## **Great North Road Solar and Biodiversity Park**

S51 and S55 Responses Cover Letter

Document Reference – EN010162/APP/1.1A

**Application by Elements Green Trent Limited: Great North Road Solar and Biodiversity Park (Application Reference: EN010162)**

2.6 WATER BODIES IN A RIVER BASIN MANAGEMENT PLAN

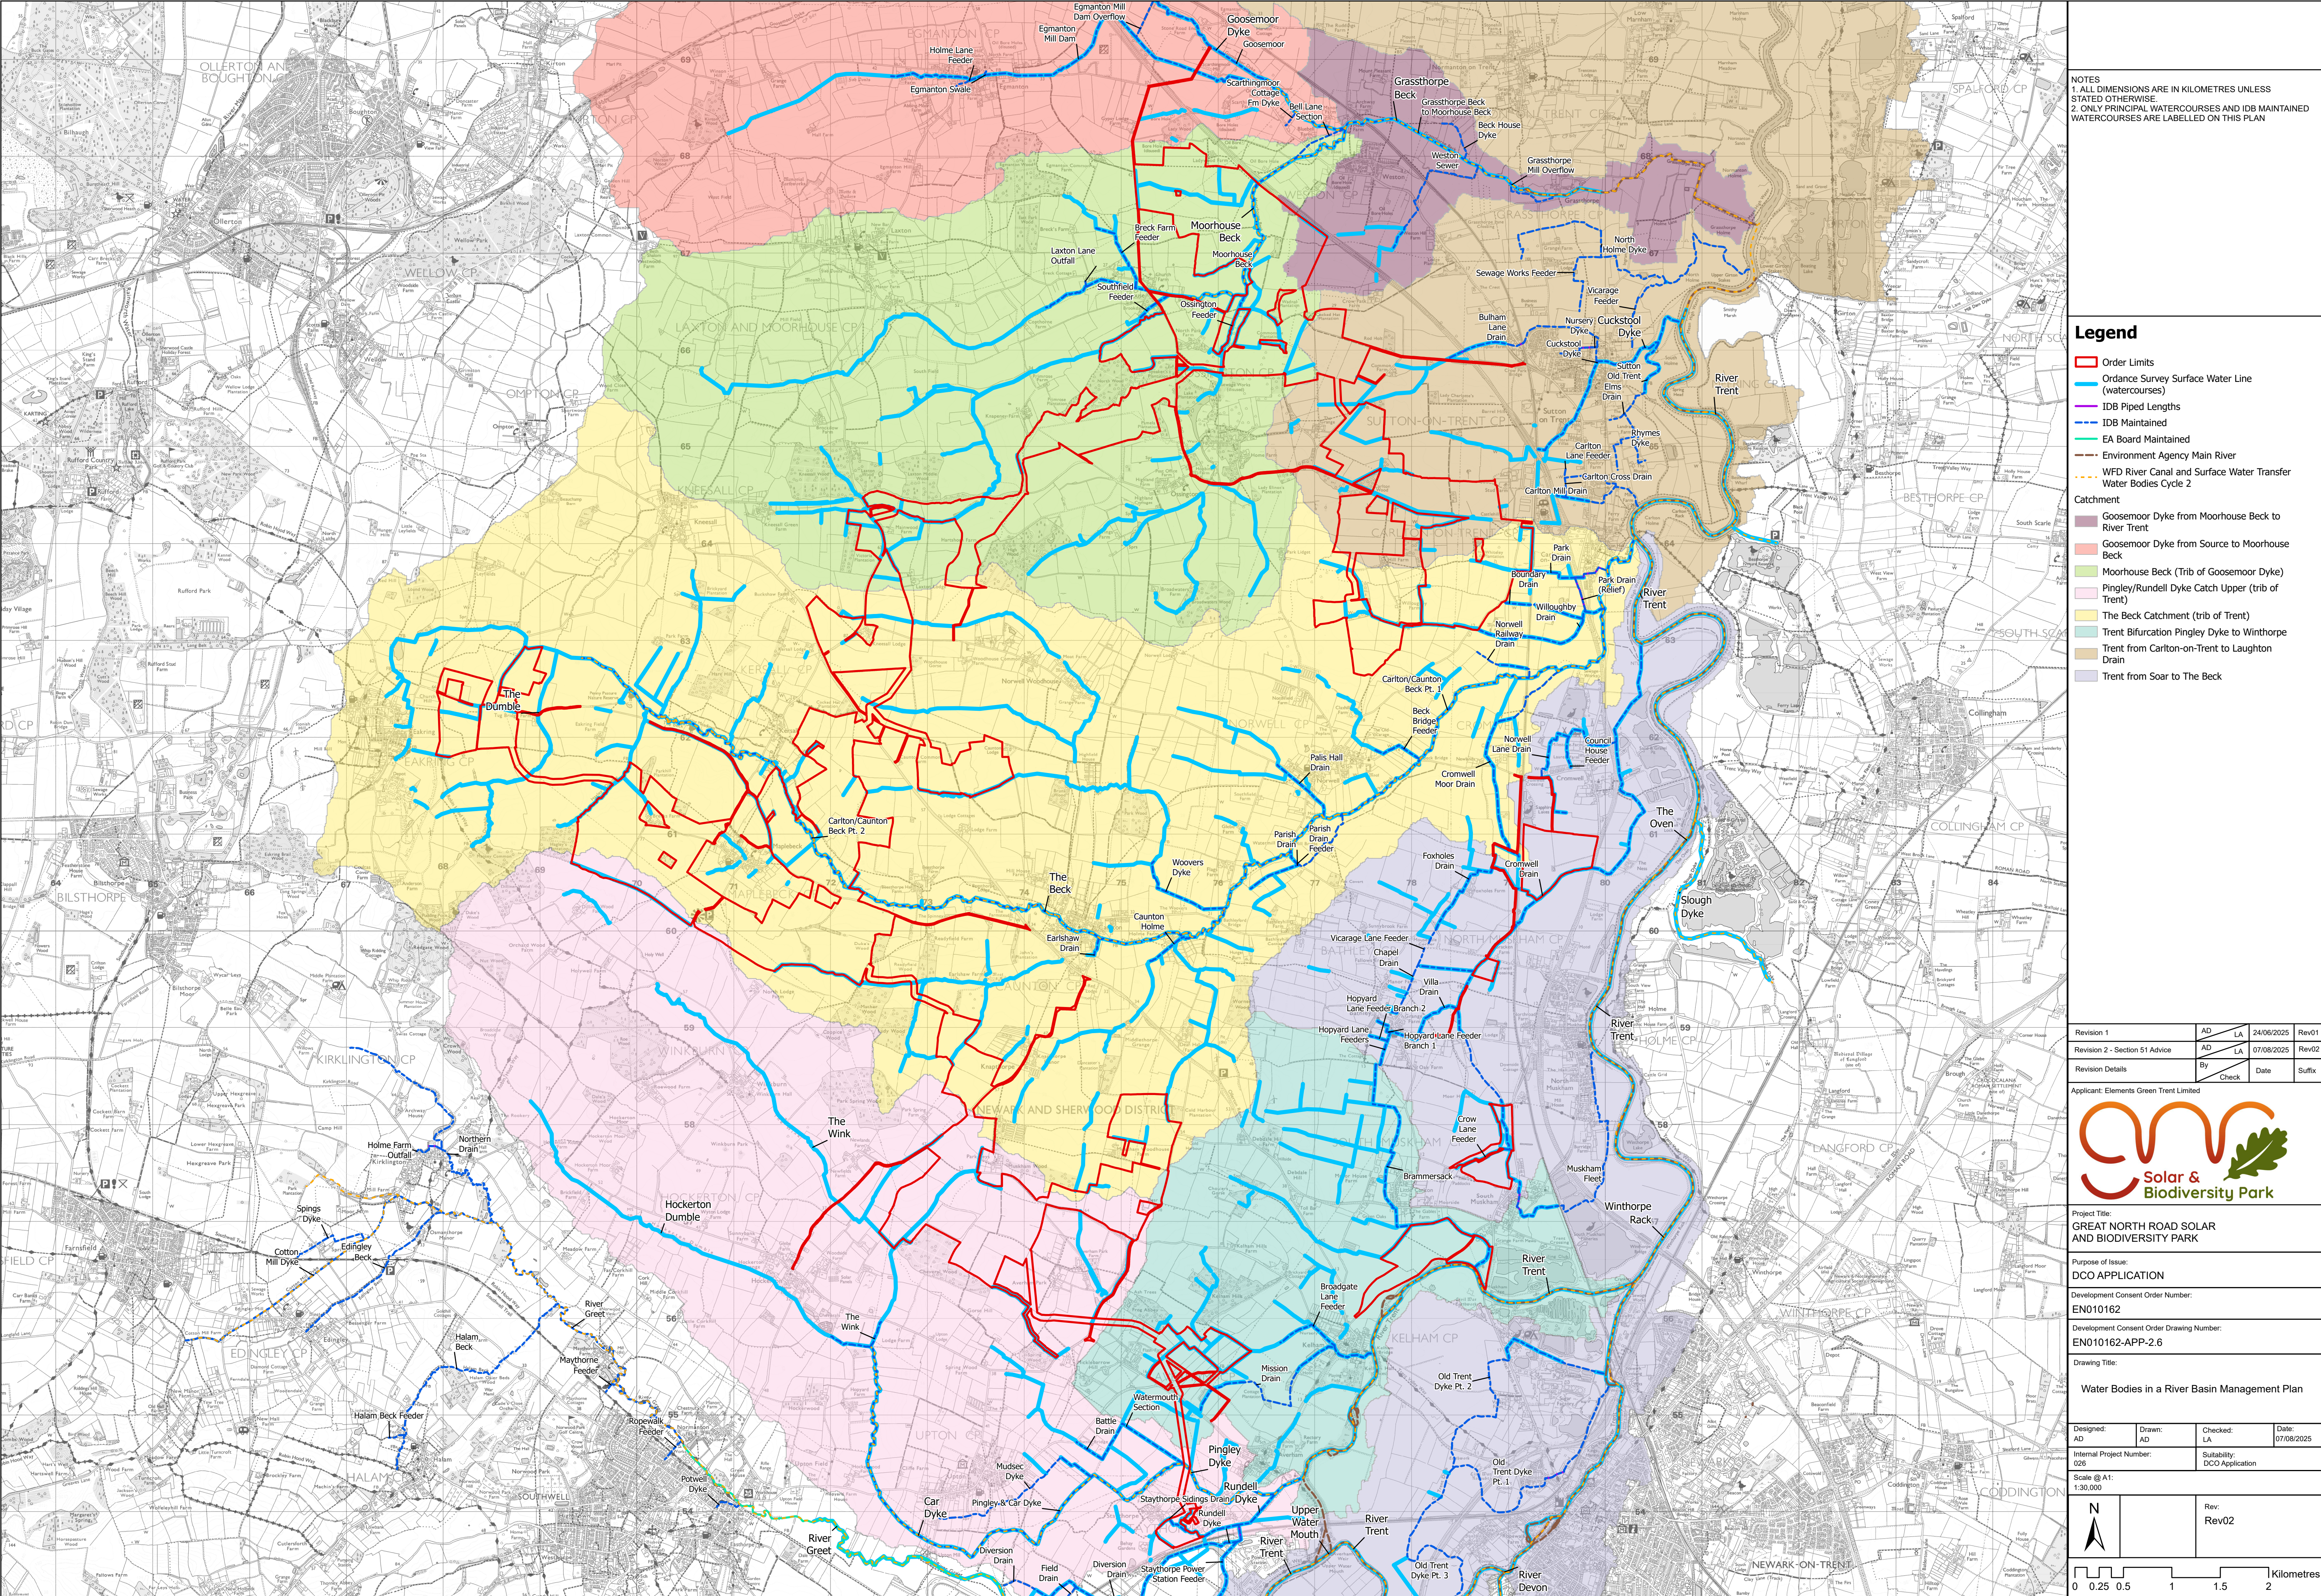
<p>The applicant is advised to review these figures for clarity and consistency. The figures present varying levels of detail, geographic extent and sub sections/ catchments, waterbody naming and waterbody routes. The Inspectorate advises that the figures should show a consistent presentation of data. The figures should also show, where relevant, the extent of main rivers and ordinary watercourses.</p>	<p>Noted. The figures within the management plans and ES figures have been updated to improve symbology and labelling for watercourses and to revise scale for clarity. This is to ensure a consistent presentation of the rivers/watercourses on the plans. The revised documents are listed below:</p> <ul style="list-style-type: none"> <li>• <b>Water Bodies in a River Basin Management Plan [EN010162/APP/2.6A]</b></li> <li>• <b>ES Volume 3, Figure 9.4: Watercourses within CSA [EN010162/APP/6.3.9.4A]</b></li> </ul>

- **ES Volume 3, Figure 9.6: IDB Maintained Watercourses [EN010162/APP/6.3.9.6A]**
- Figures within the updated **ES Volume 4, Appendix 9.1: Flood Risk Assessment [EN010162/APP/6.4.9.1A]**
- Figures within the updated **ES Volume 4, Appendix 9.2: Water Framework Directive Assessment [EN010162/APP/6.4.9.2A]**
